DOC20/824175

Senders ref: SSD 10395 (Blacktown)

**Subject: Notice of Exhibition – Cleanaway’s Western Sydney Energy and Resource Recovery Centre, 339 Wallgrove Road, Eastern Creek (SSD 10395)**

Figure No
D.04

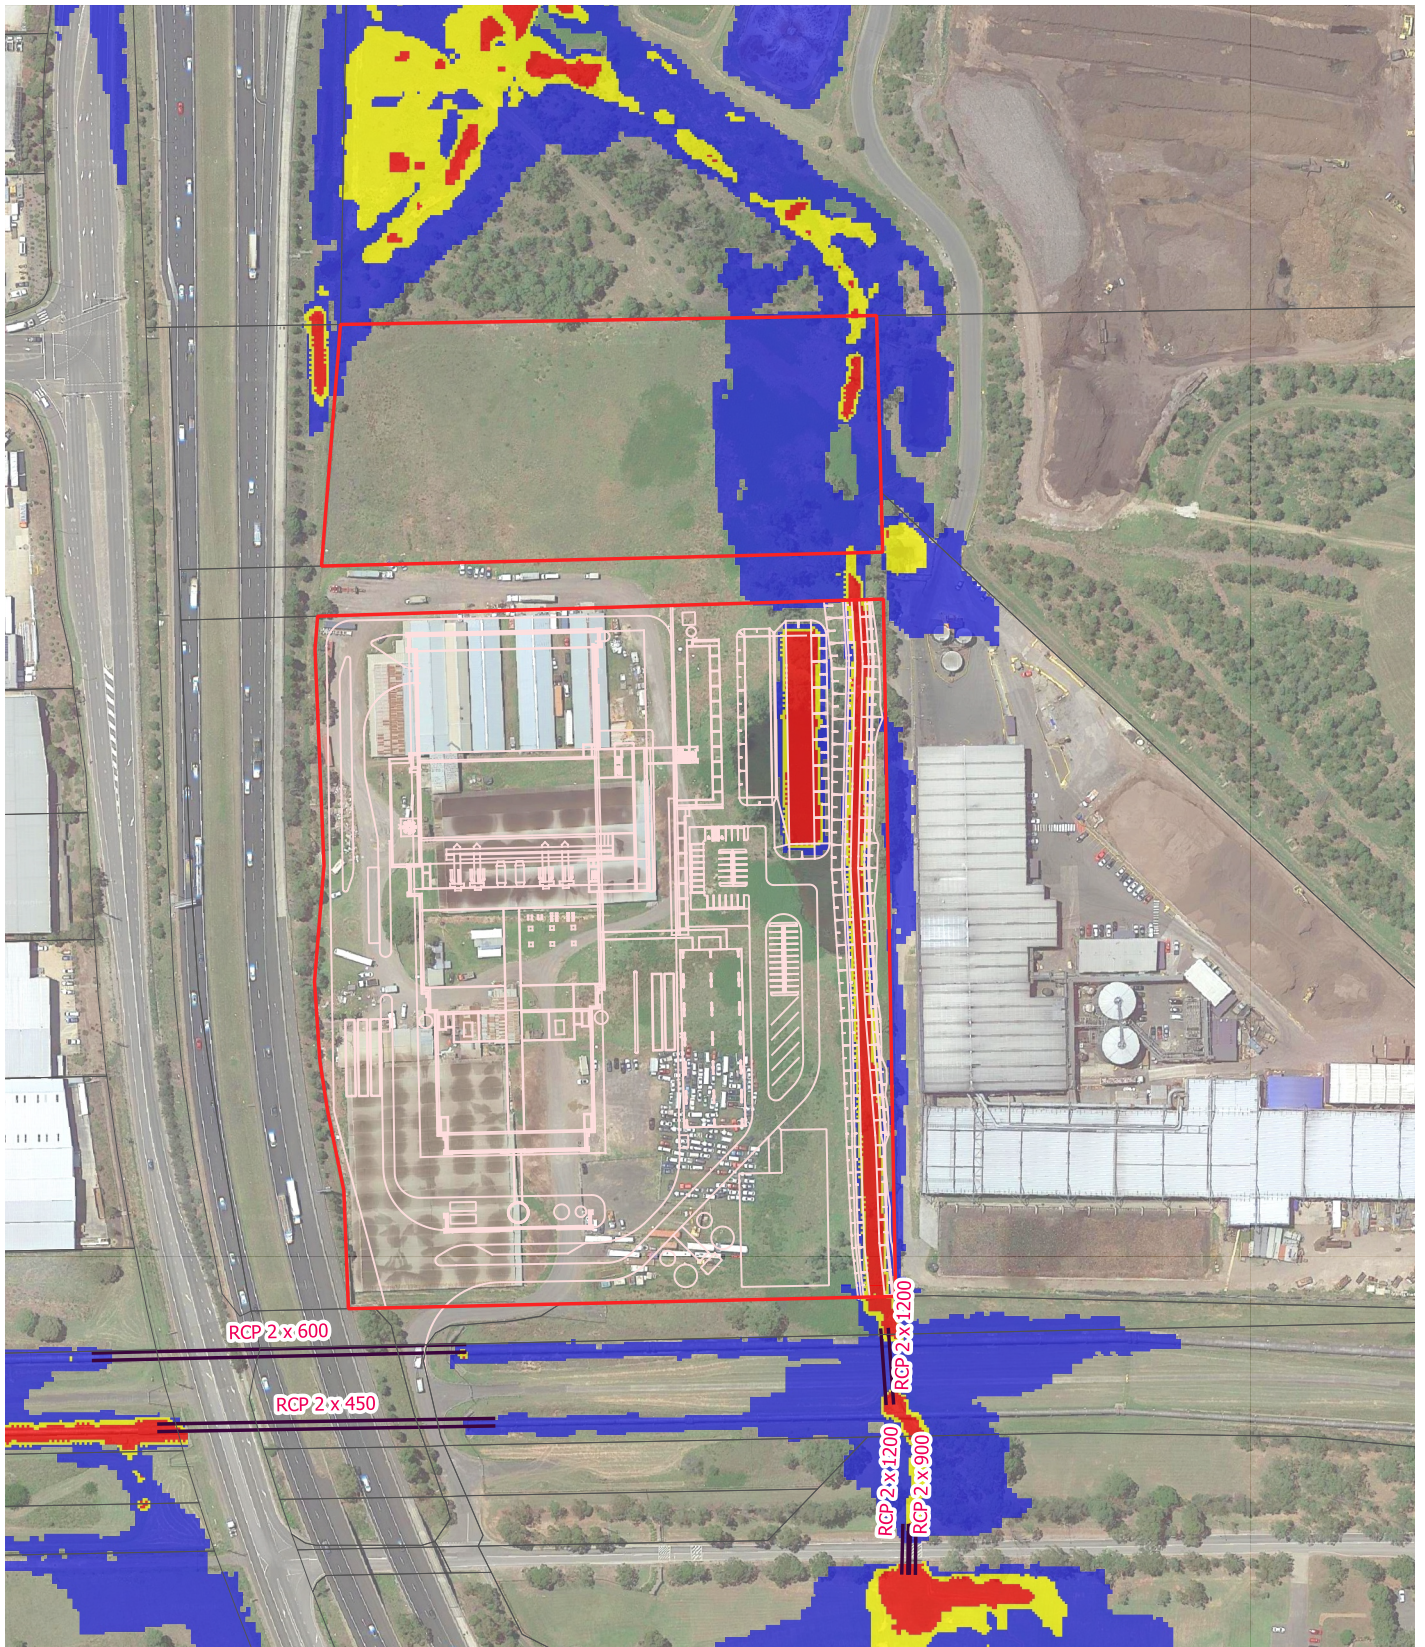
Figures D.04 and D.08 of FIA show the site is isolated in the PMF event. EES recommends that a flood emergency management response plan be prepared, in consultation with Blacktown City Council and the State Emergency Service, to address the safety of the personnel, visitors and users of the site.
